PW1192_Planning Statement - March 2022.
Supporting Statement for Prior Approval Application for
Conversion of Agricultural Barns to Residential at
Elm Farm, Somersham Road, Little Blakenham

A Class Q application was submitted in December 2021 (ref: DC/21/06654/PN3), but was subsequently withdrawn due to a number of concerns that were raised during the consultation process. All of the concerns have been addressed as follows:

Barns A & B - Typical Structural Plan - 1:100

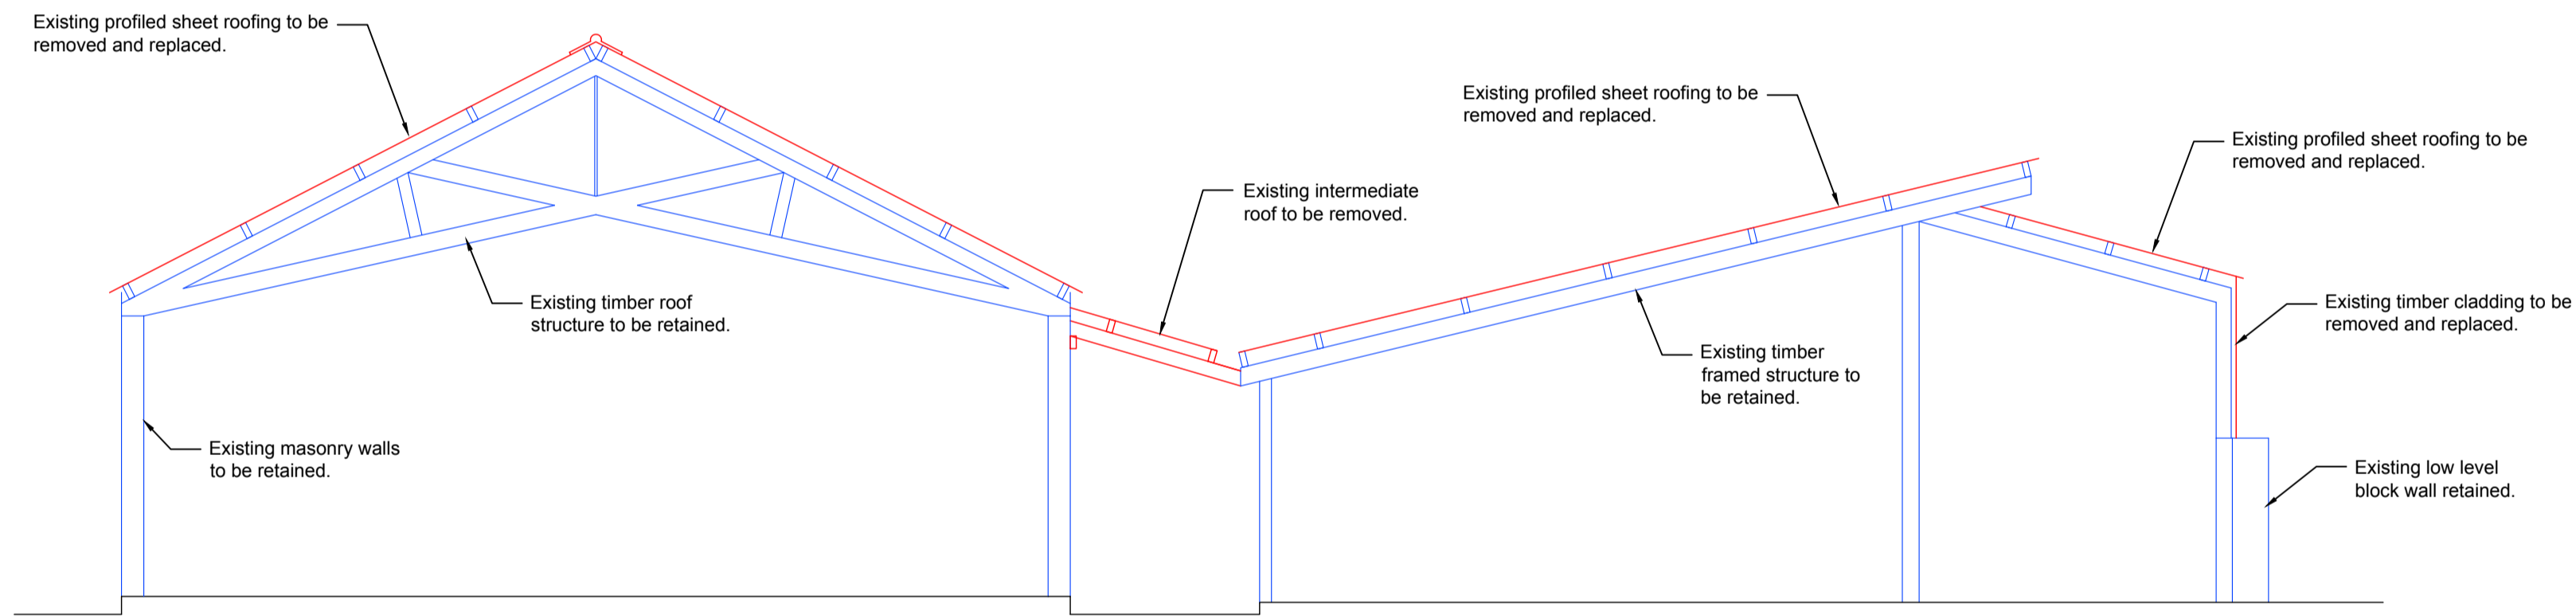
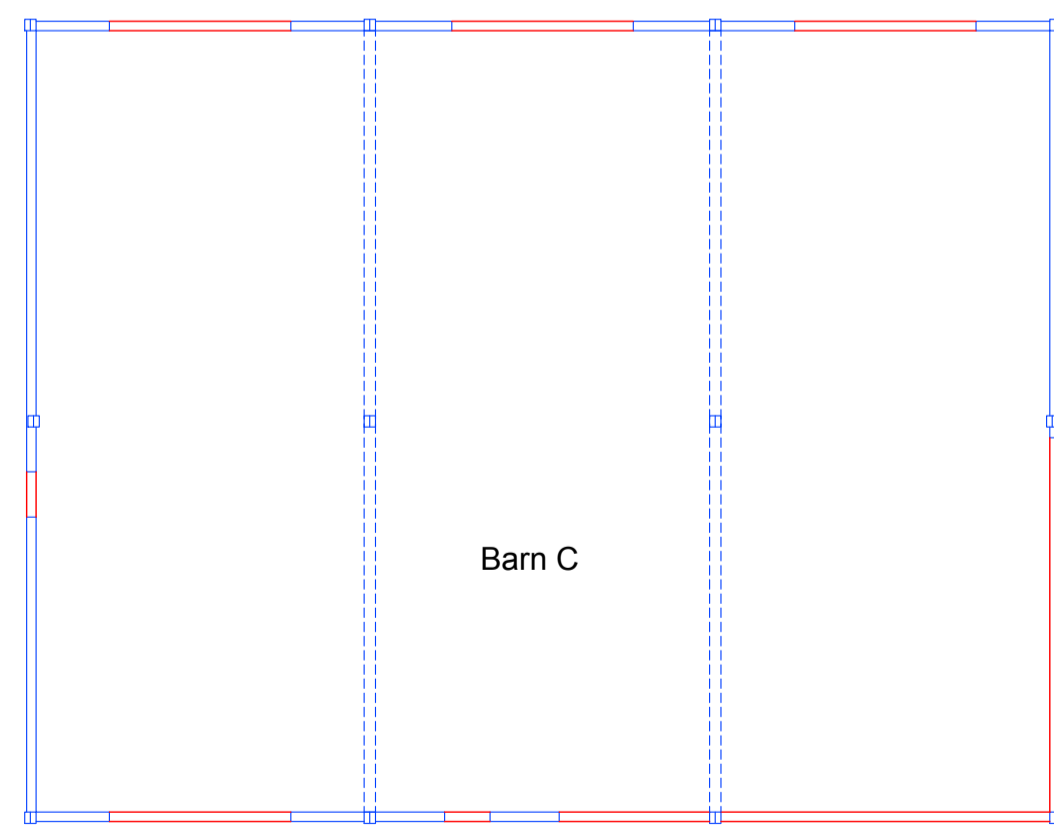
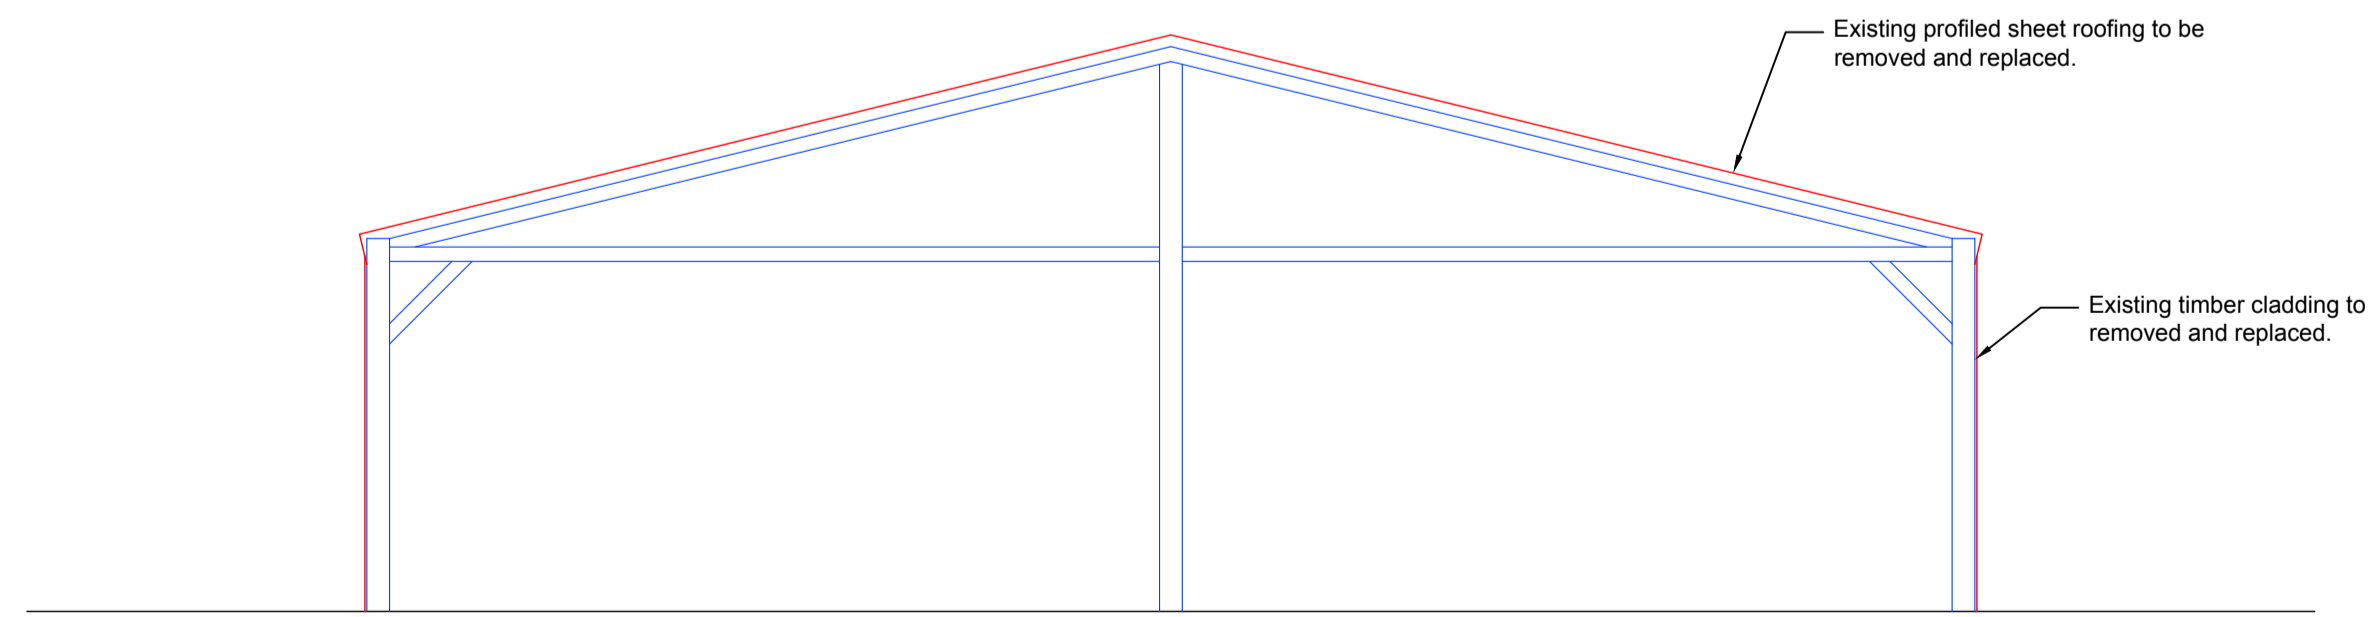
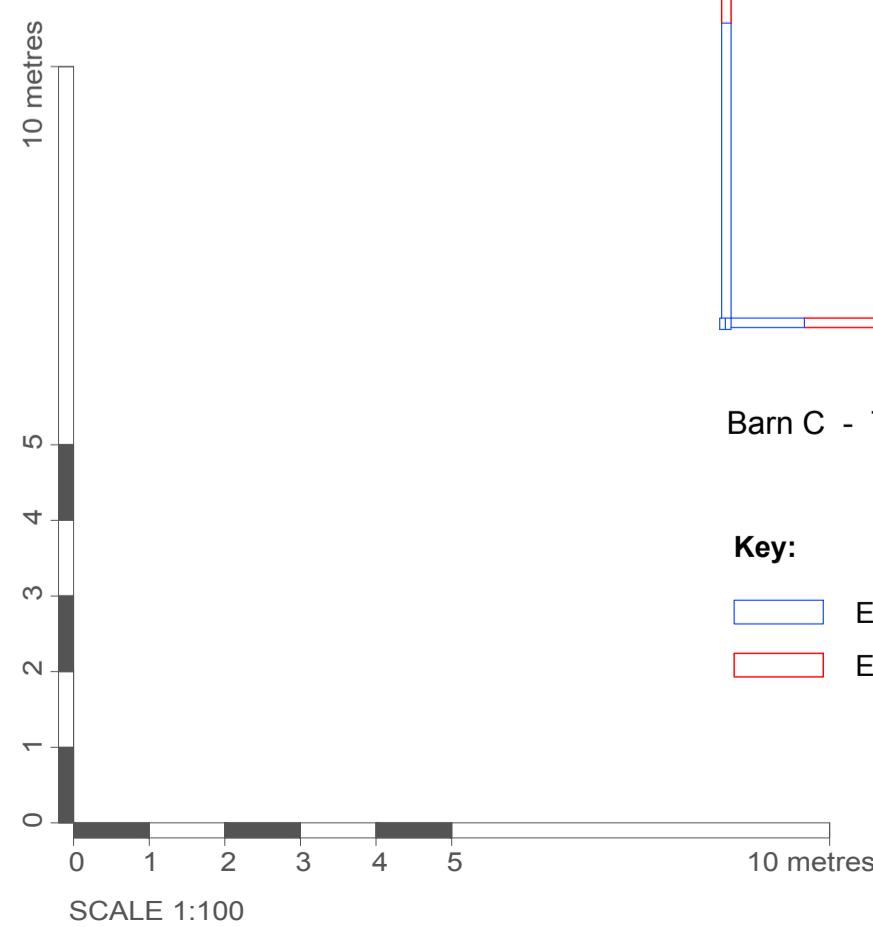
- *“I did also note that there may be the replacement/ alteration of the walls/ roof as detailed within the planning statement. Whilst this is not necessarily opposed, for the purposes of Class Q as we are essentially granting a conversion and noting that I may not be dealing with a resubmission, we will need to be clear on specifically which areas are to be altered and which ones are to be replaced so we understand the extent of the building operations proposed”*.

We have produced a new drawing PL205, that illustrates which parts of the buildings are to be retained and which are to be removed.
